EN010092 Thurrock Flexible Energy Centre

Gravesham Borough Council

Written Representation (WR) and responses to ExQ1

Viewpoint 20 Figure: 4.11a

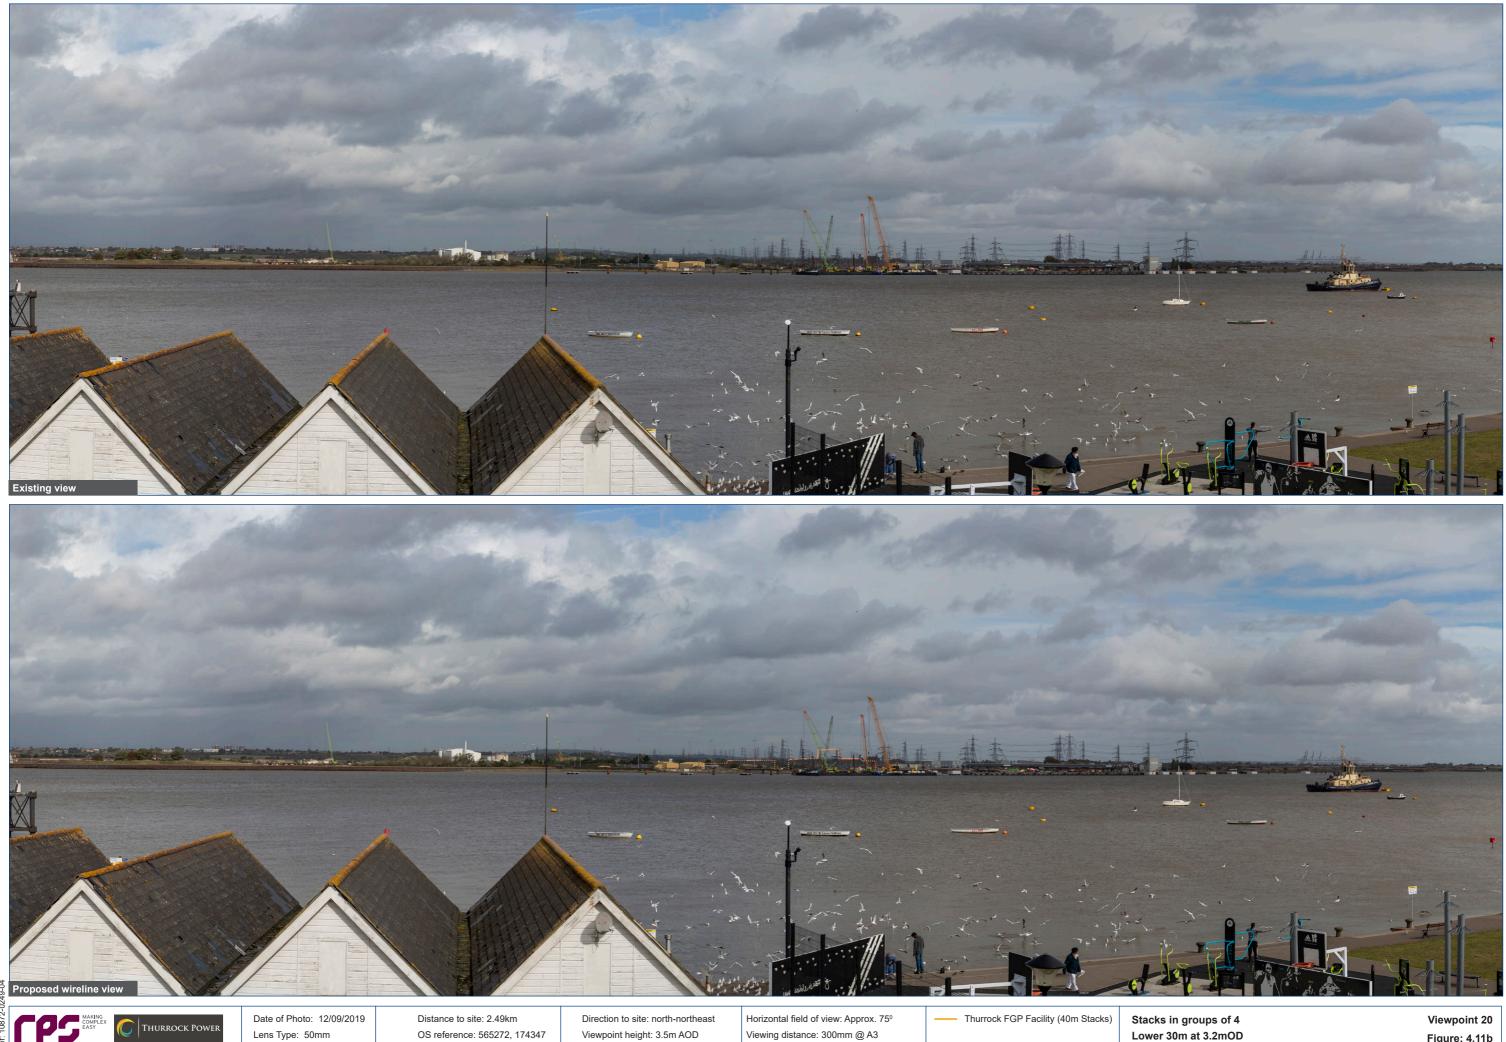
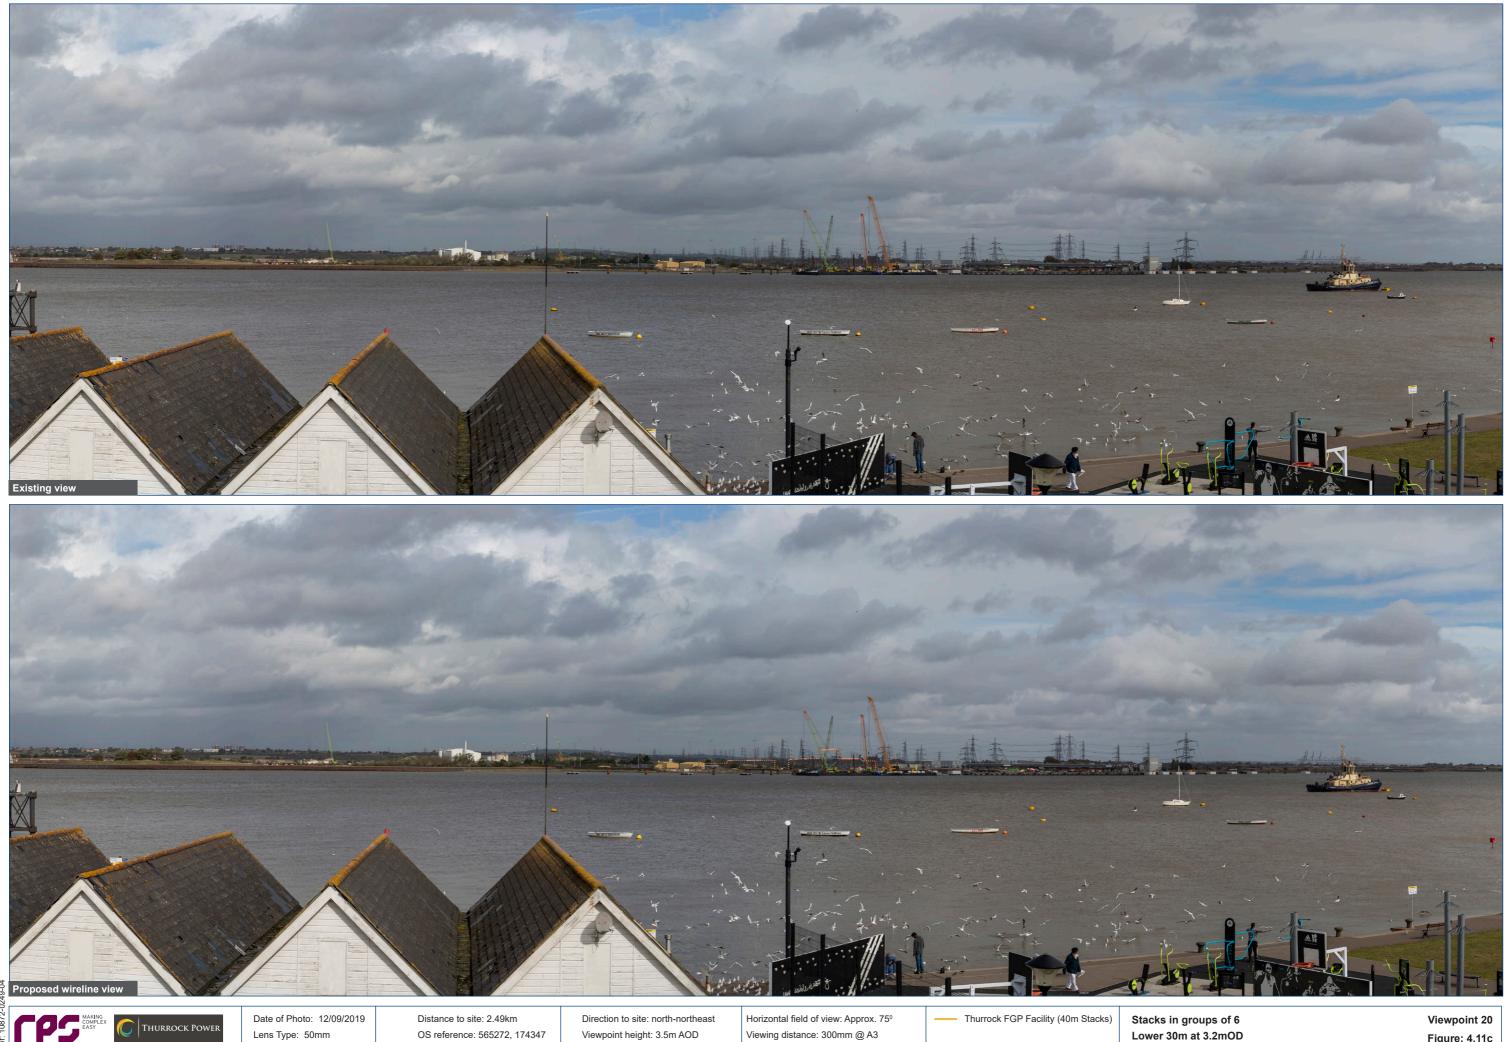
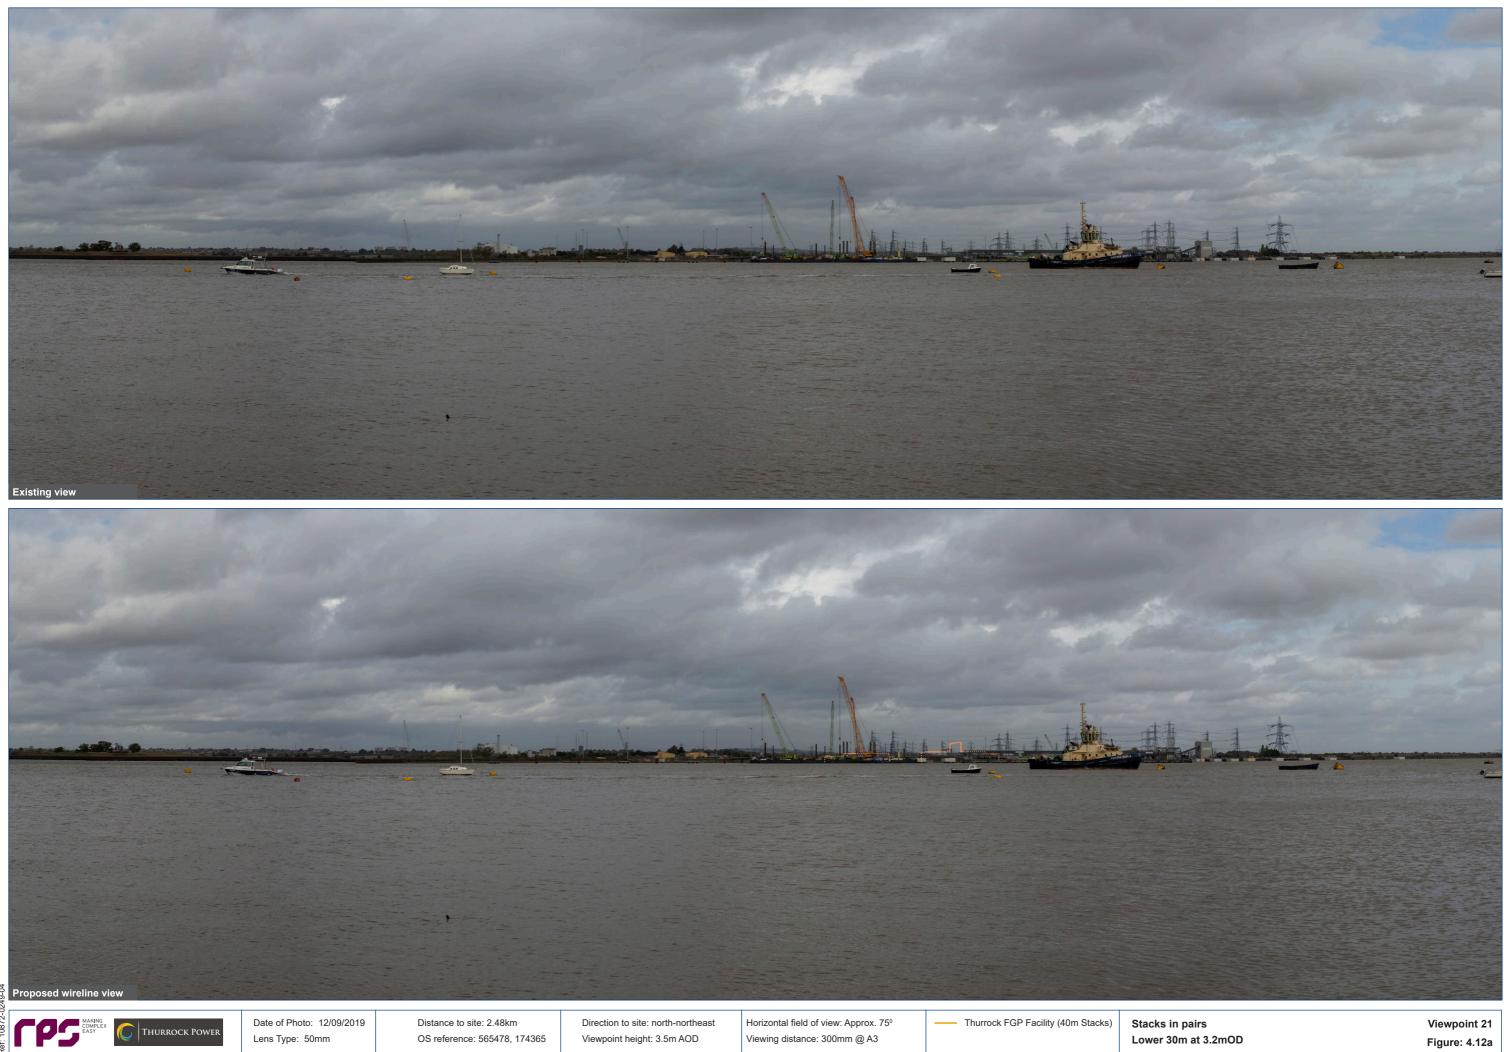
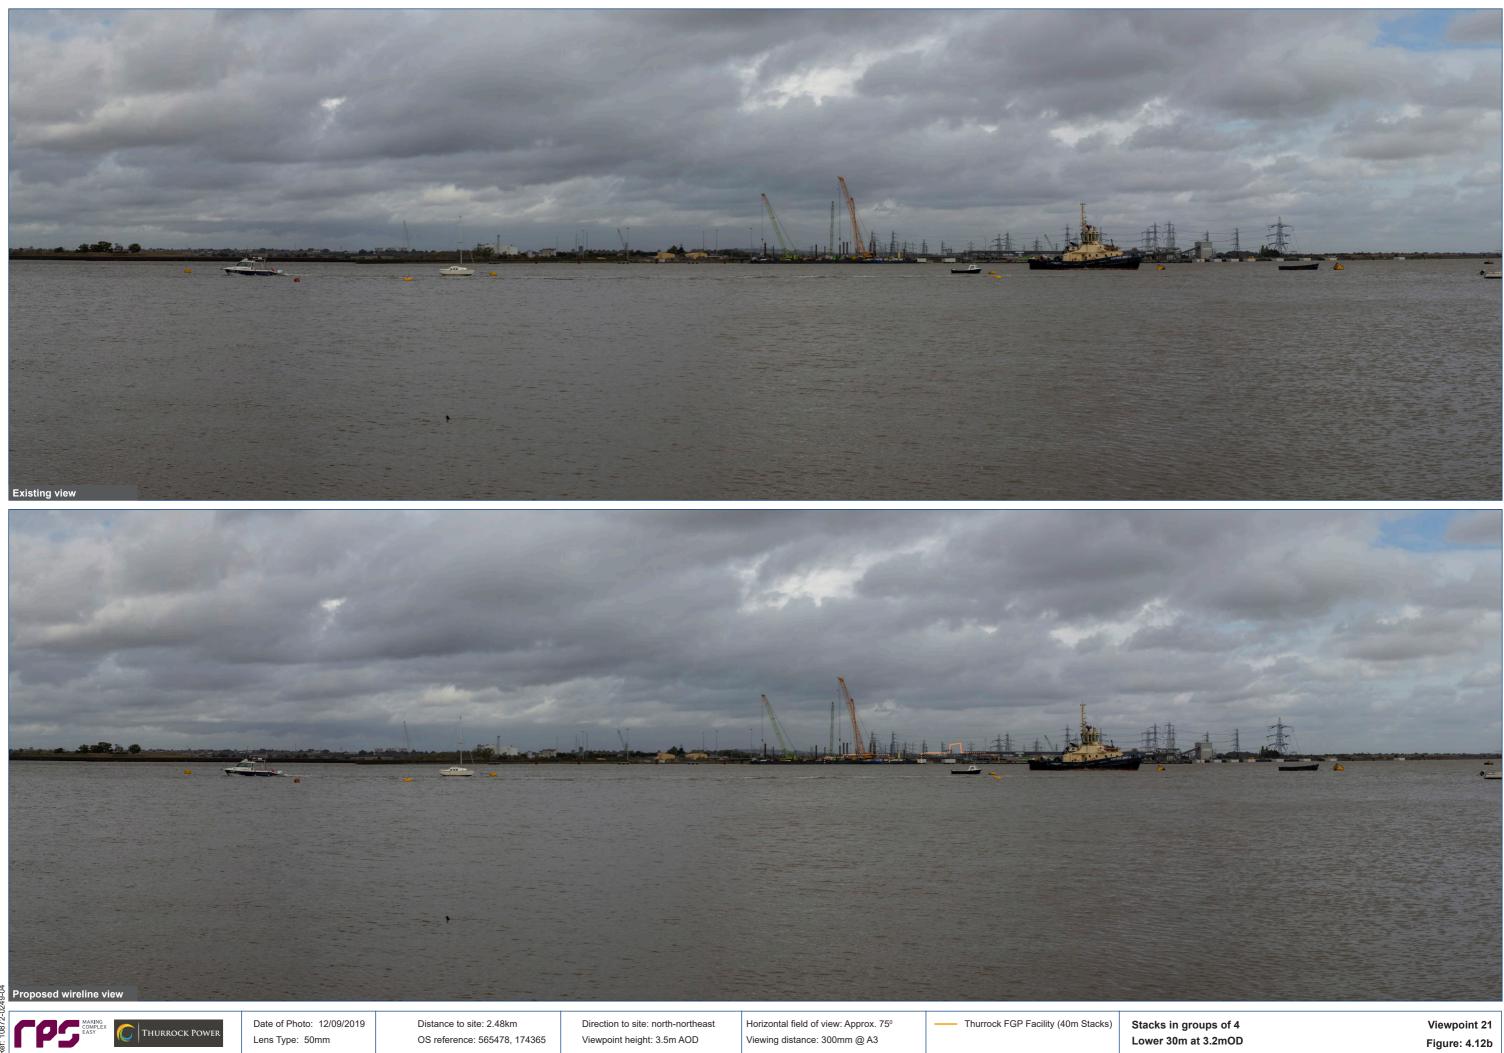
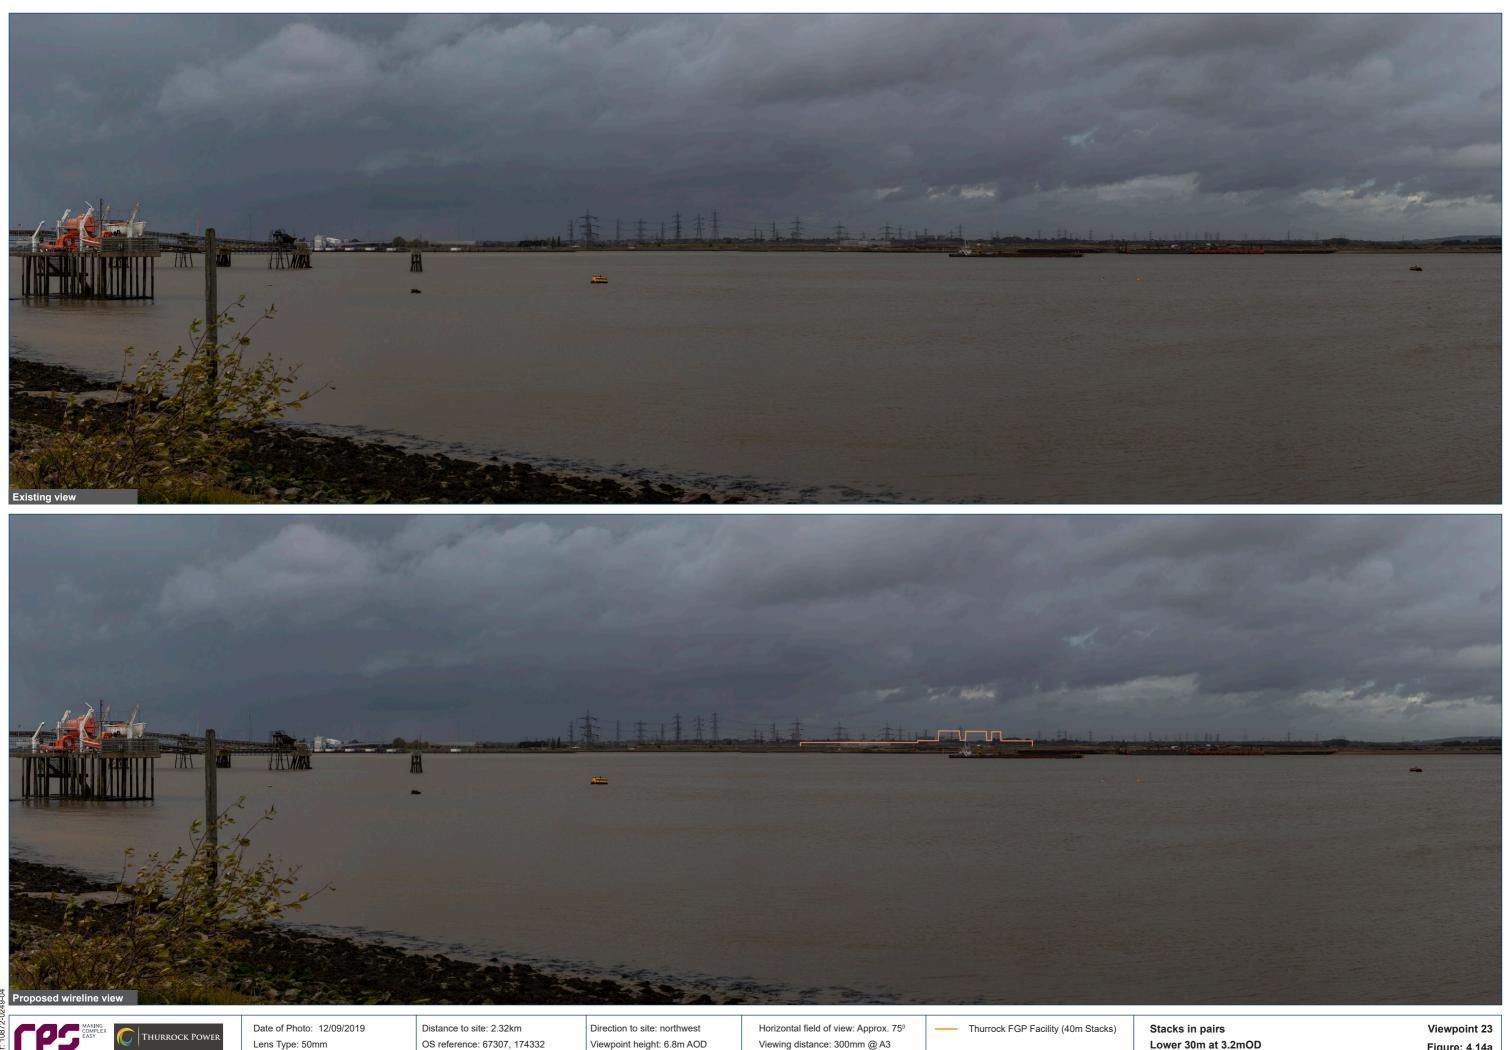
- 5.14 1.12.1 *Have the representative viewpoints been agreed.* The Borough Council has reviewed the landscaped views provided by the applicant in chapter 6 of the ES, the locations of which were previously agreed by the Council. In terms of the operational plant itself the views illustrate that the stacks, as the highest element, are generally not prominent in long distance views or else become lost in the pylons and other structures that exist in any case.
